## Application for a Non-Material Amendment Following a Grant of Planning Permission

Purse Ryde Cottage Westwood Lane

proposed that the ground floor windows are to be increased in width from 600mm to 900mm wide. Both the windows are now in the dinning area.

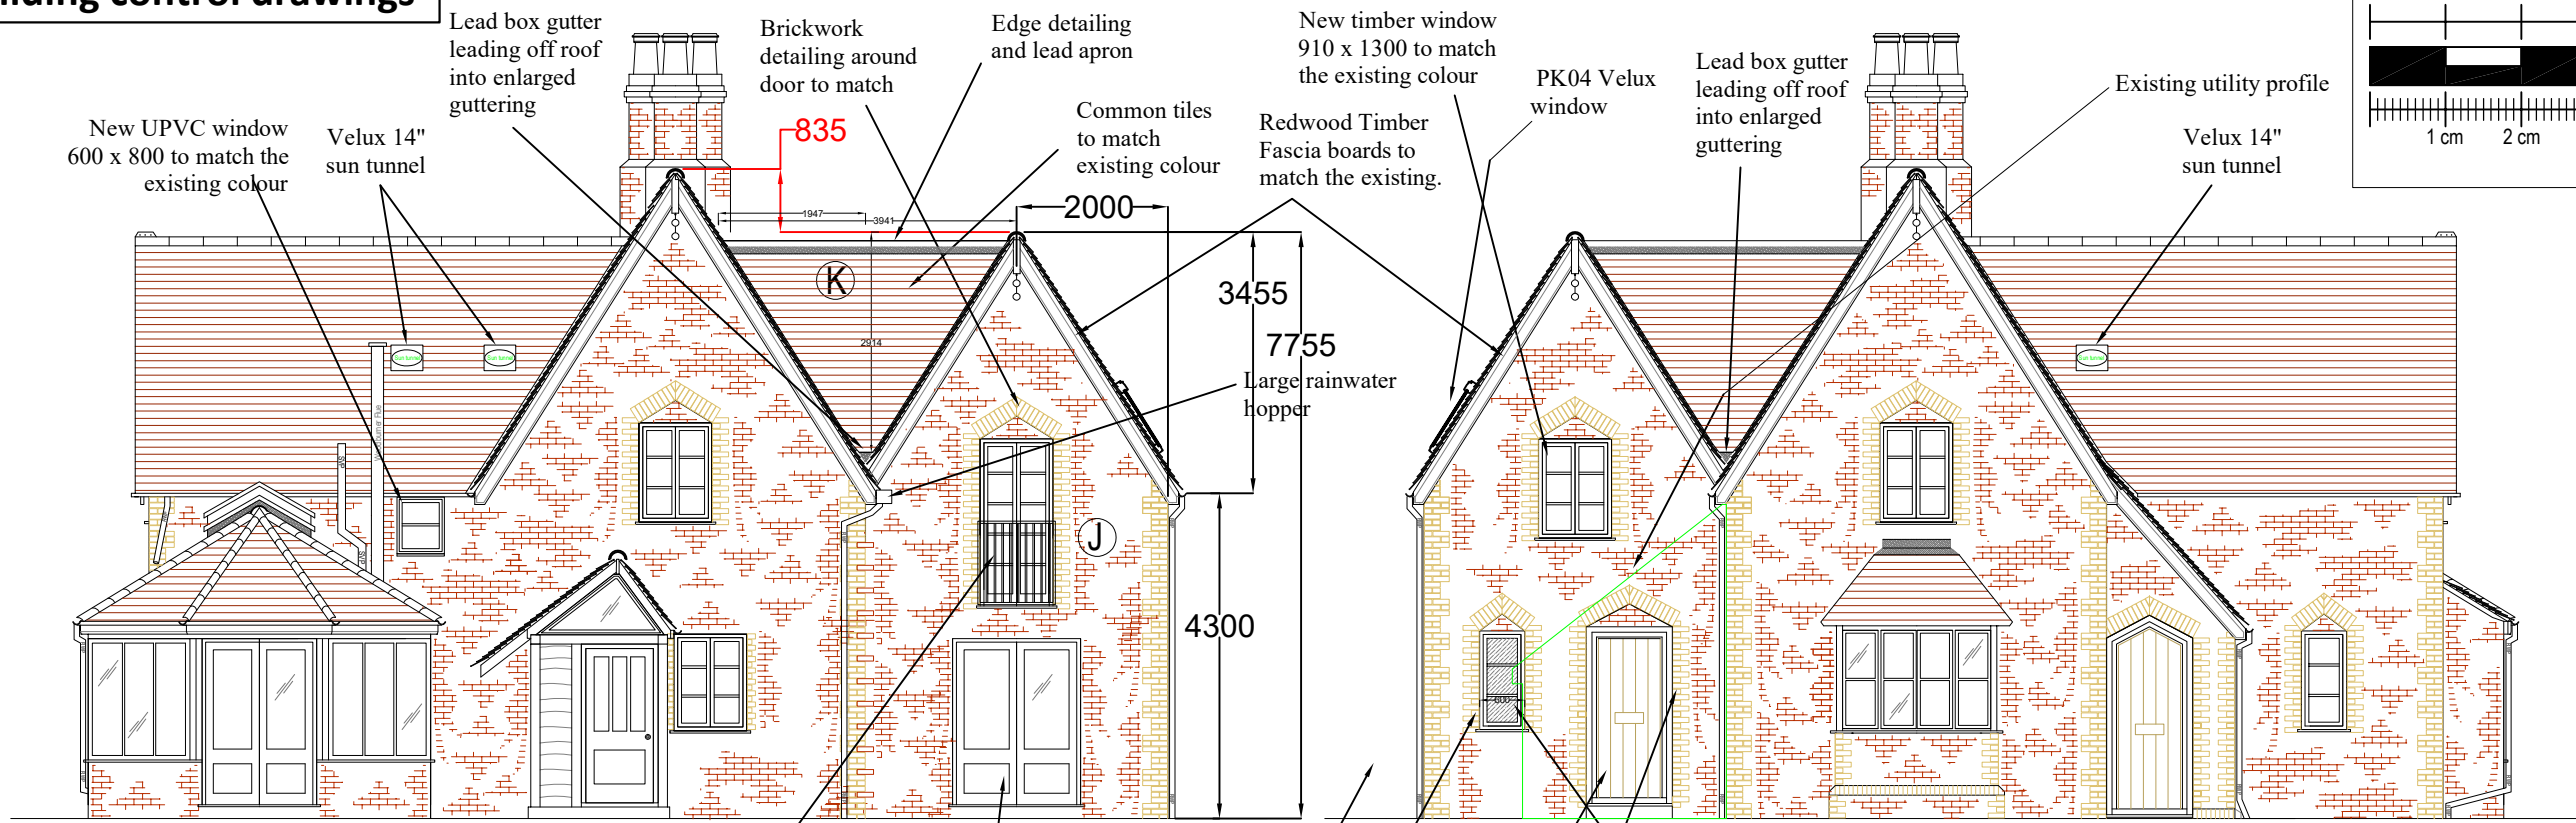
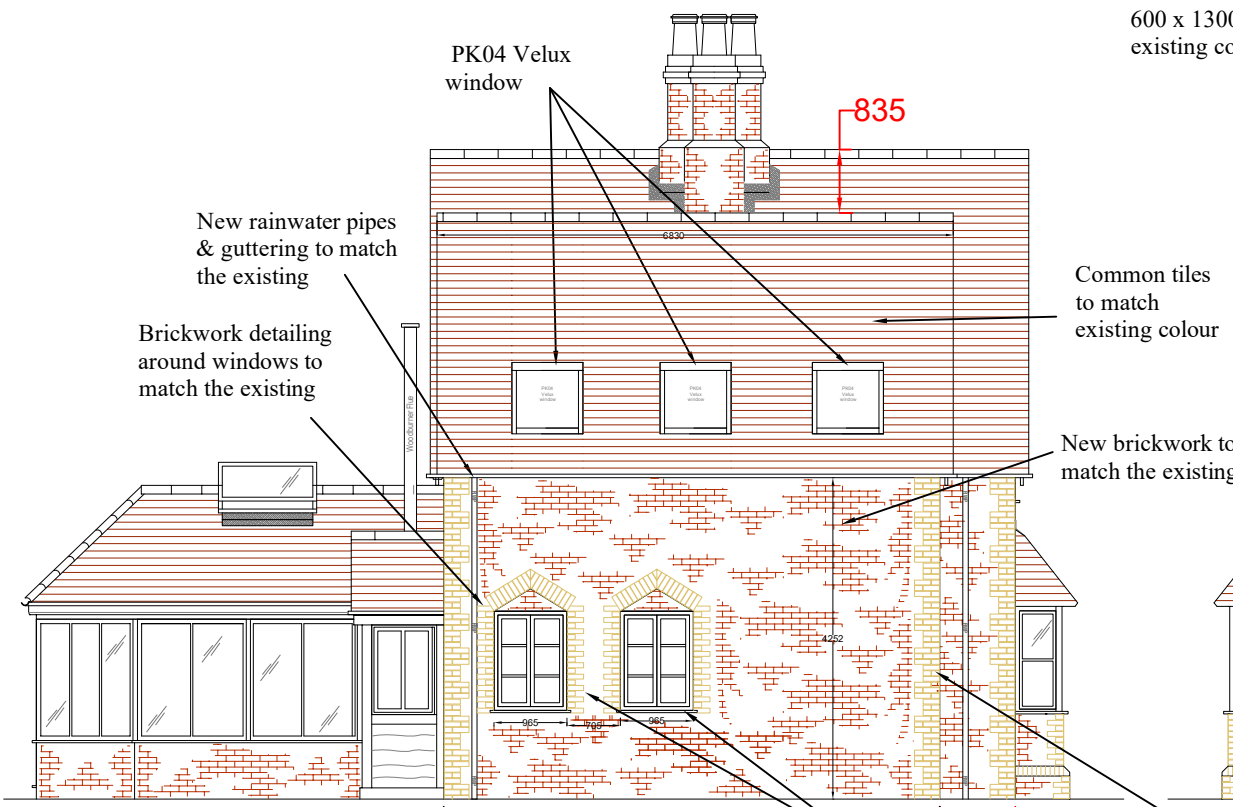
An additional velux window has been proposed in the ensuite and the side facing windows have been increase slightly in size.

Existing front door is to be retained and not replaced with a new window.

Bedroom 4 glass balustrade with a brushed steel guarding

Both the ground floor side windows are now in the dinning area to give more natural light into this area. and to allow a better view of the driveway.

The velux size increase to give more light into the new bedroom 4 and an additional velux window in the ensuite for more natural light.
